# DRAINAGE AND TRANSPORTATION INFORMATION SHEET

**SUBJECT: ABUNDANT LIFE GYMNASIUM**  
**Grading and Drainage Plan (M10-D0006)**

Submitted herewith for review and approval are 2 copies of the Grading and Drainage Plan and Supplemental Calculations. The Plan and Calculations have been revised to address the comments issued by Amy Niese, PE, on December 2, 2014. Specifically, the comments have been address as follows:

POND OVERFLOW SPILLWAY

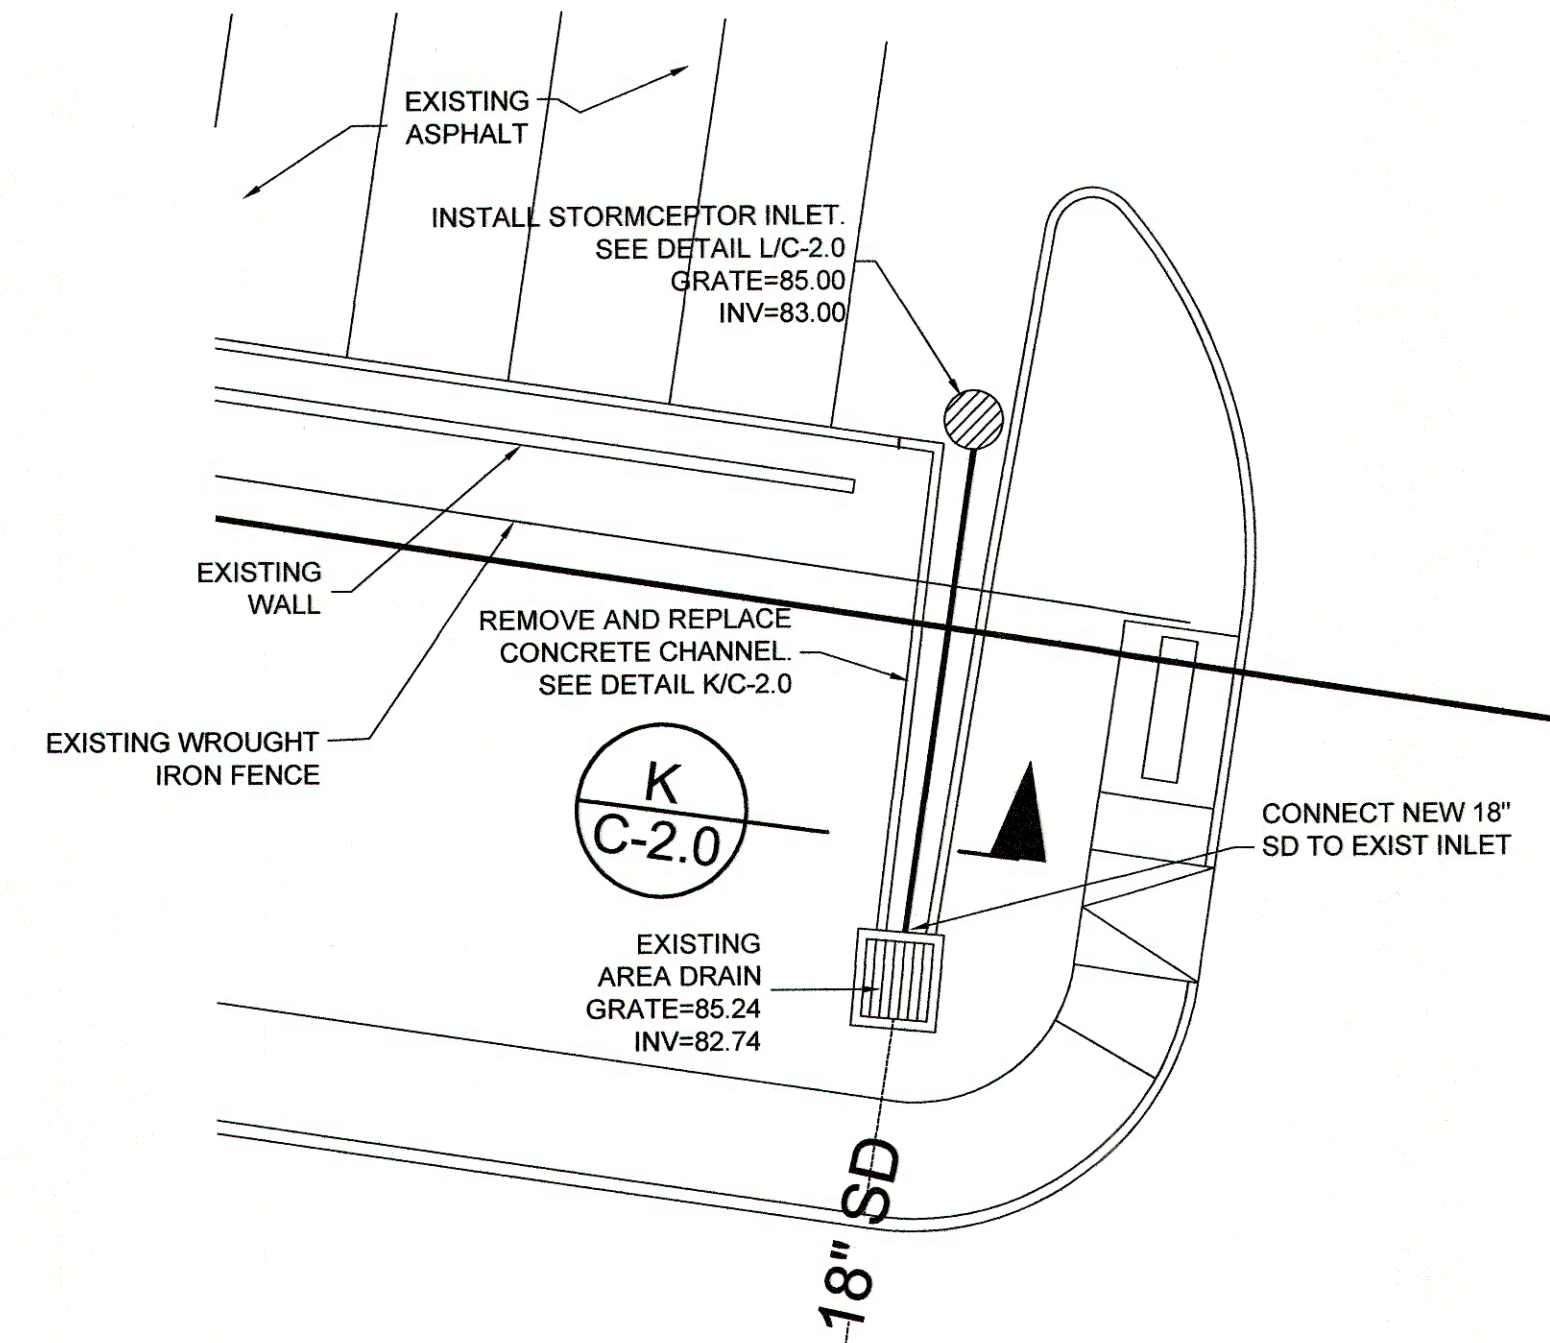
6. The overflow elevation of the spillway is 88.50 vs. 88.40 at the accepting asphalt.
7. The plan illustrates all spot elevations reported on the topographic survey. I have visited the site and verified that positive drainage exists in this area.

DRAINAGE CHANNEL DETAIL
NTS

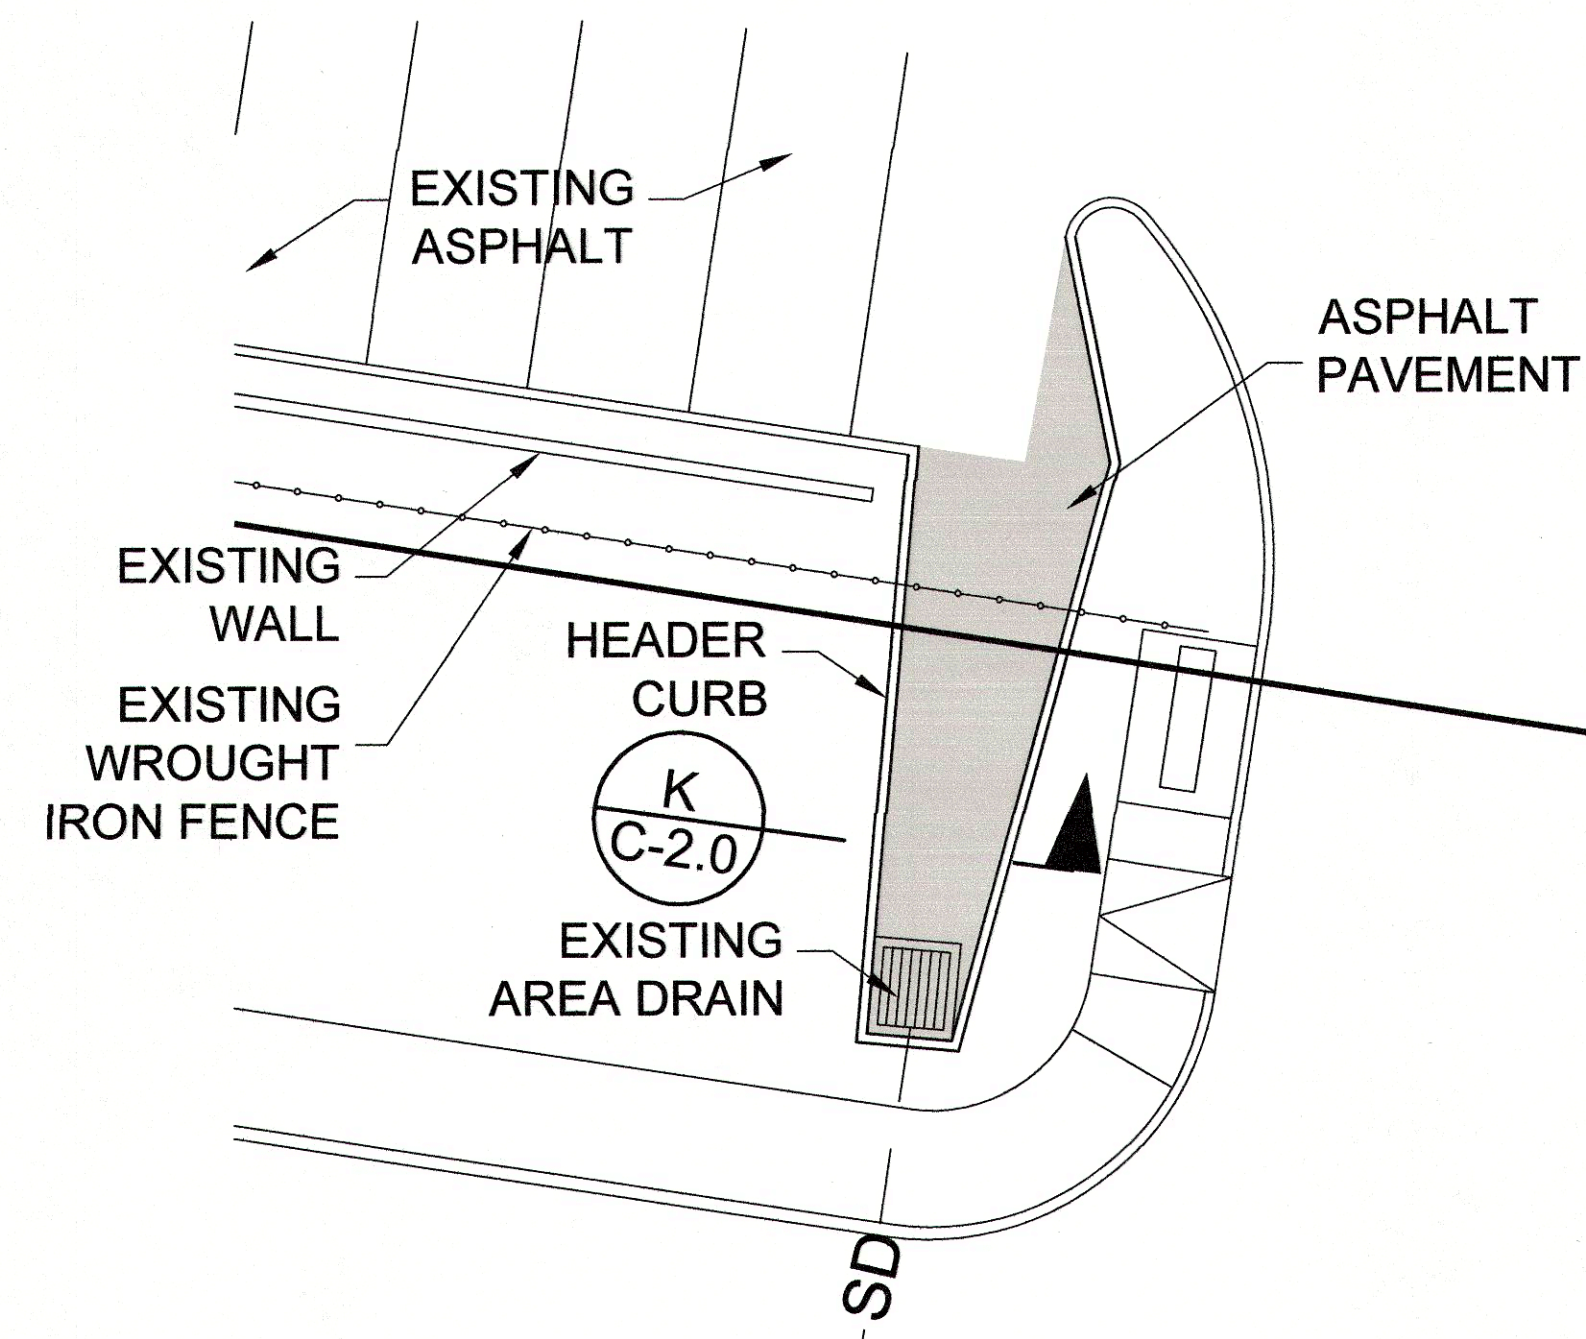
2. Two (2) copies of the plan are provided for SO 19 purposes.
3. Detail J/C2.0 has been revised to include a stormceptor manhole that will capture oils and trash as required by Bernalillo County.
